Application No: LU/218/21/PL

Site Address: Land adjacent to Toddington Lane Farm Cottages Toddington Lane
Littlehampton BN17 7PP

Description of Works: Erection of a semi-detached building comprising 2 No x 2 bedroom houses with associated parking and landscaping works (resubmission following LU/58/21/PL). This site may affect the setting of a listed building & is in CIL Zone 2 and is CIL Liable as new dwellings.

Environment Officer
Environmental Protection
Chichester District Council

Proposed Site Plan - 1:100 @ A1

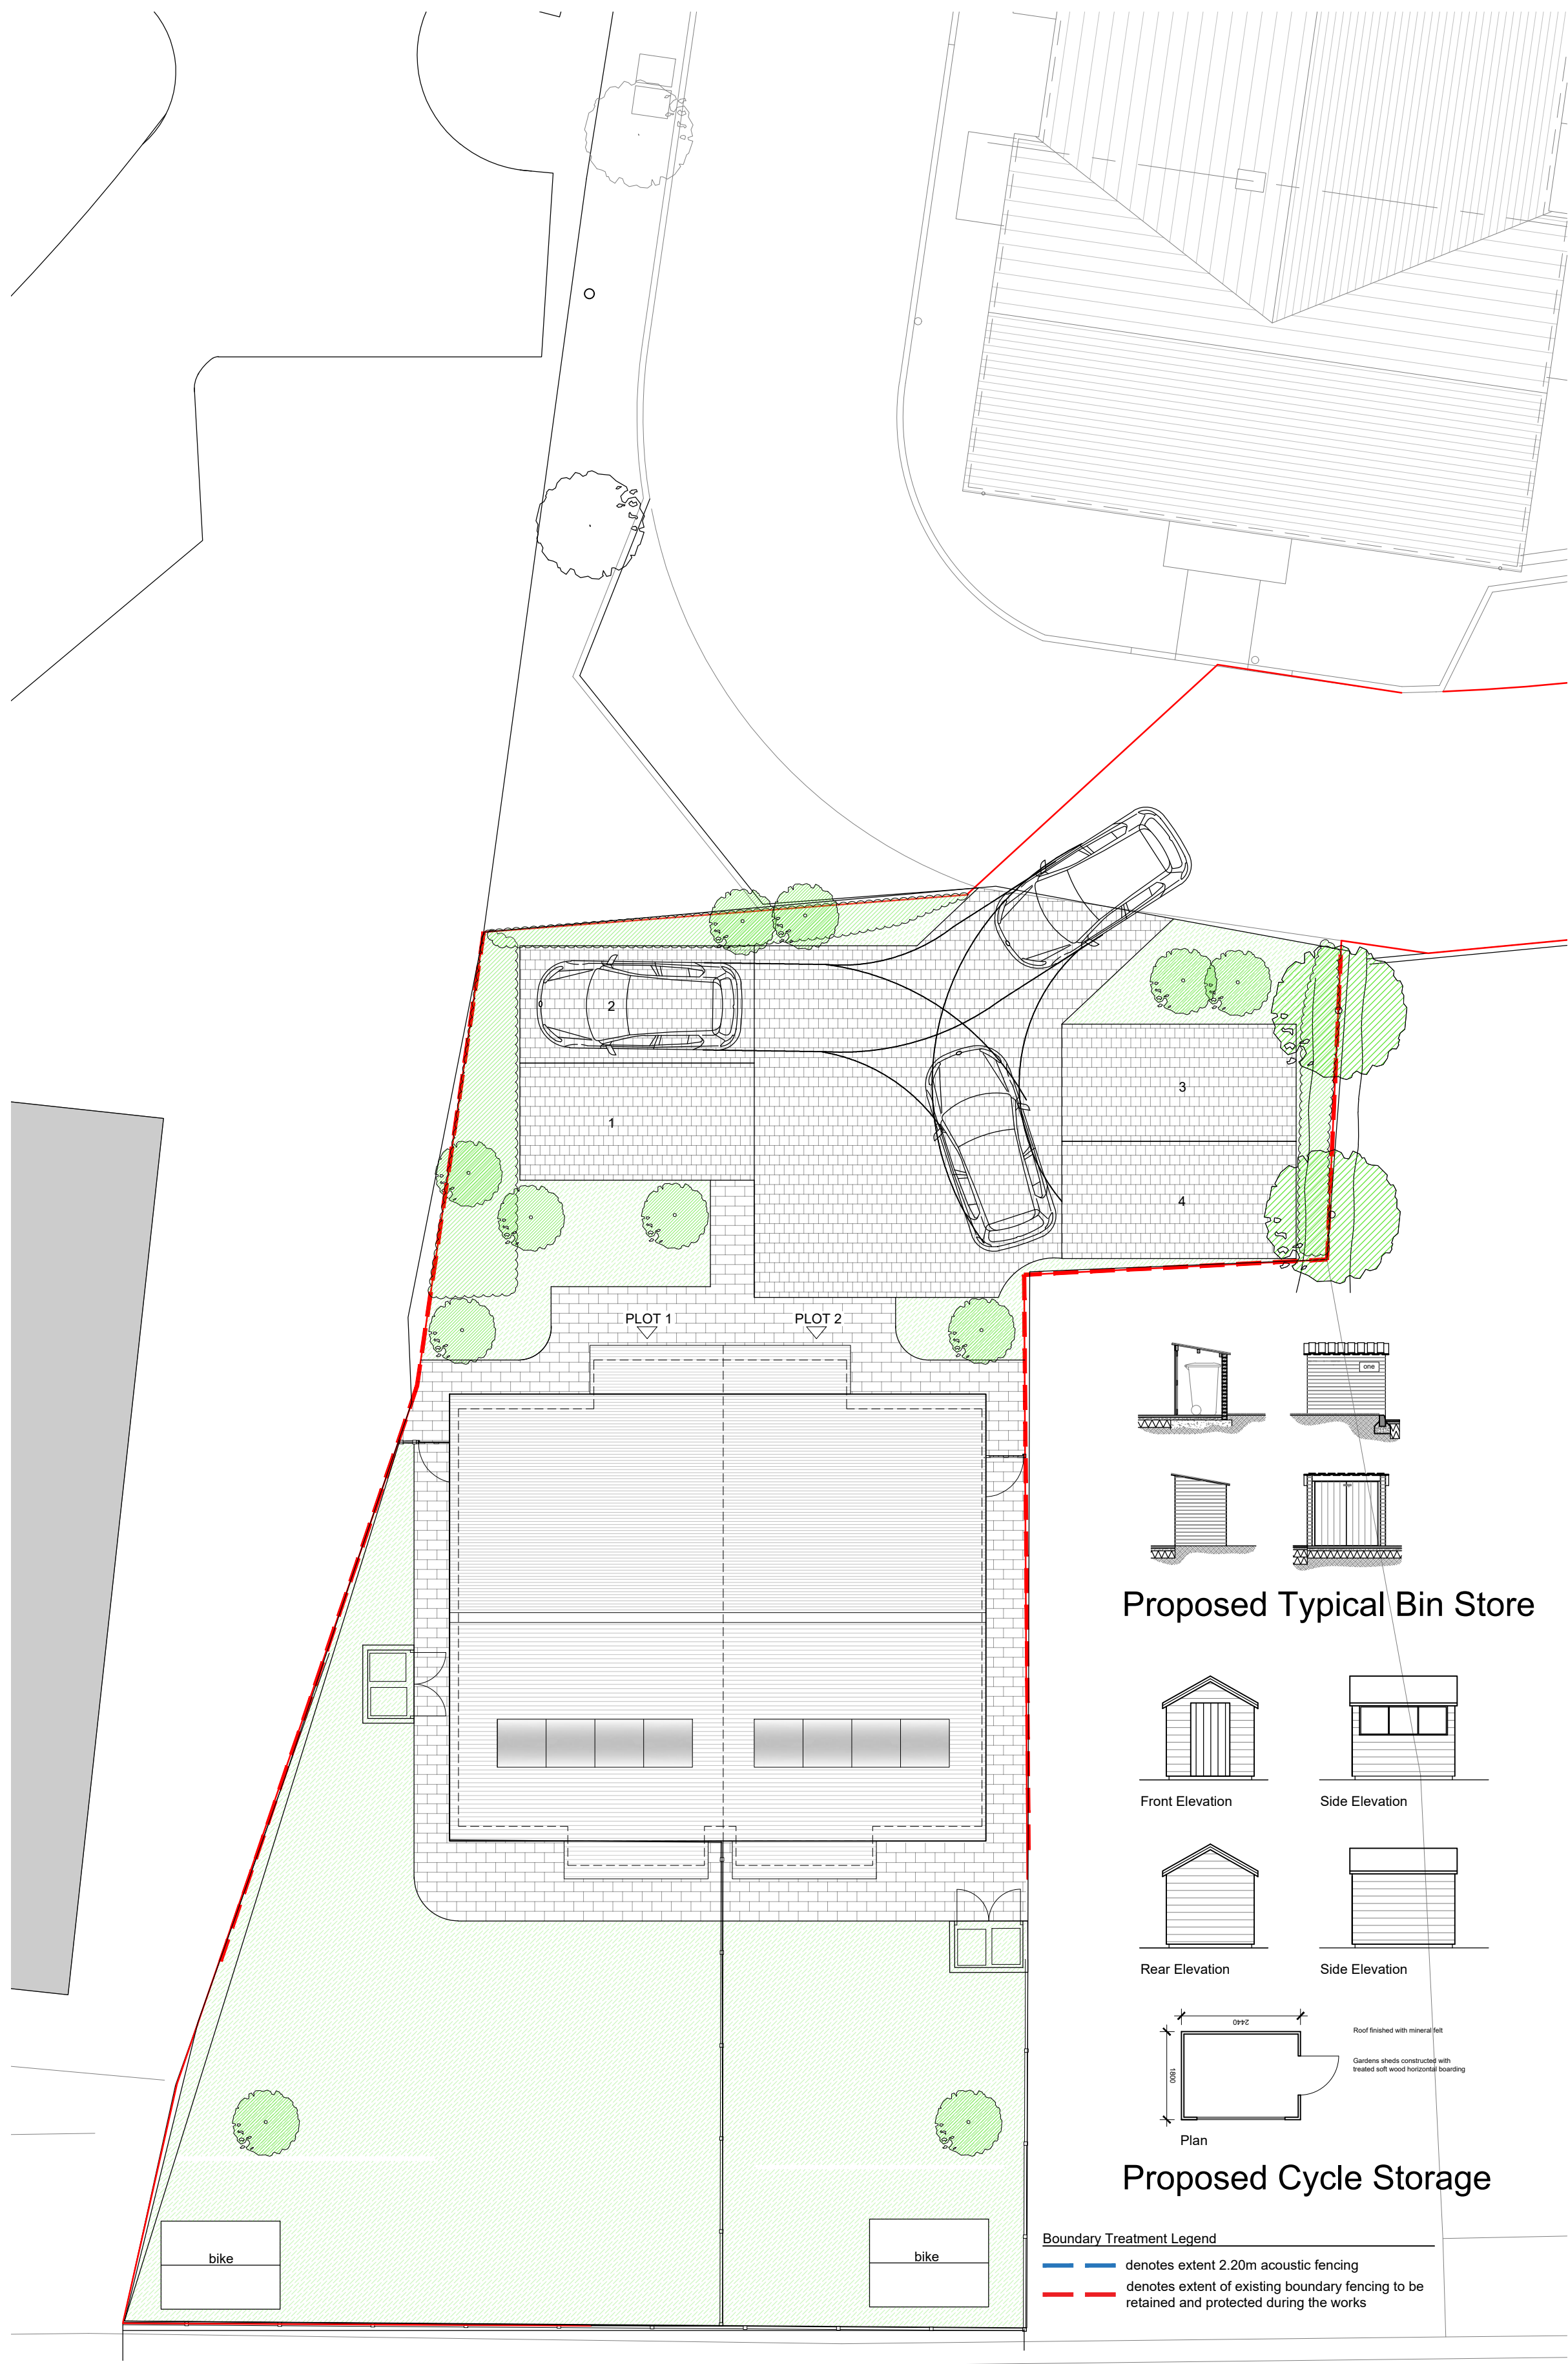
Any brush piles, compost and debris piles on site could provide shelter areas and hibernation potential for hedgehogs. These piles must be removed outside of the hibernation period mid-October to mid-March inclusive. The piles must undergo soft demolition. A hedgehog nesting box should be installed within the site to provide future nesting areas for hedgehogs

DRAWING TITLE
Elevations & Plans as Proposed
Planning Issue

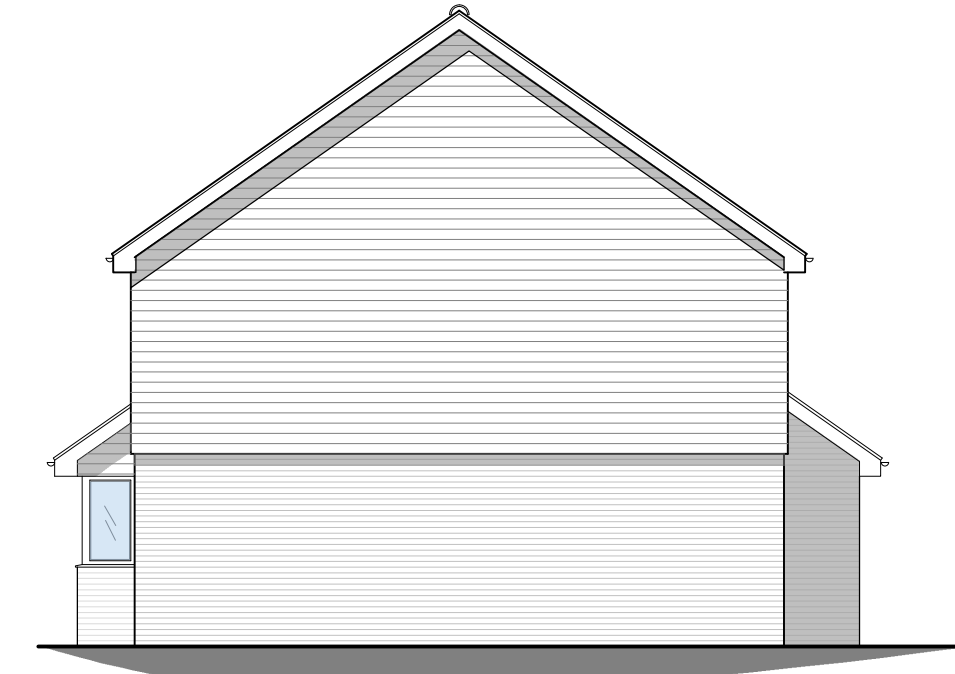
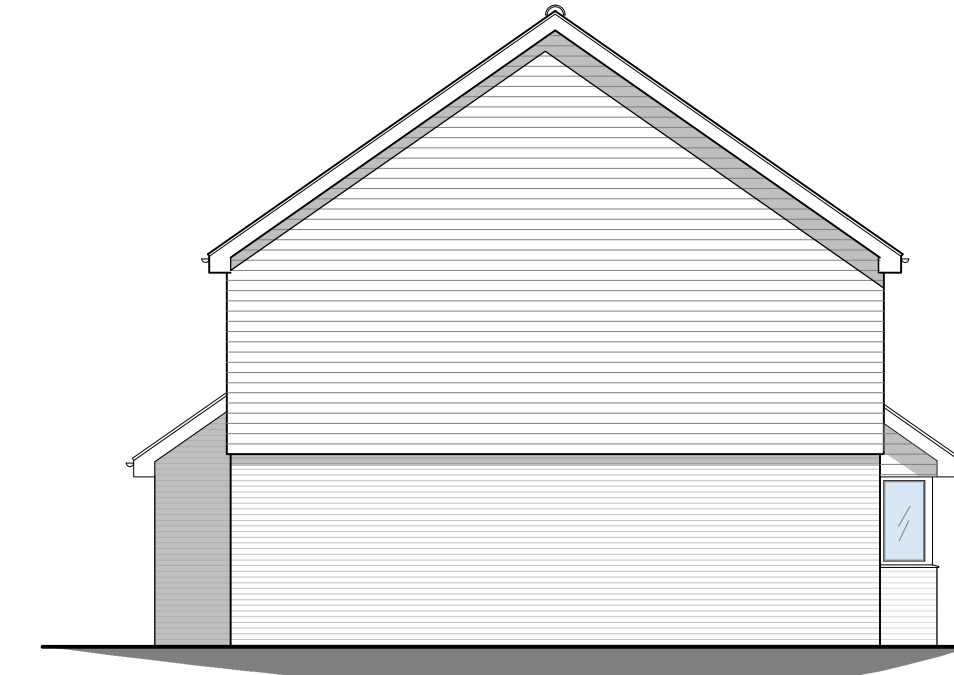
We require that a bat box is installed on the buildings onsite facing south/south westerly positioned 3-5m above ground.

We would like a bird box to be installed on the extension / and or tree within the garden of the property.
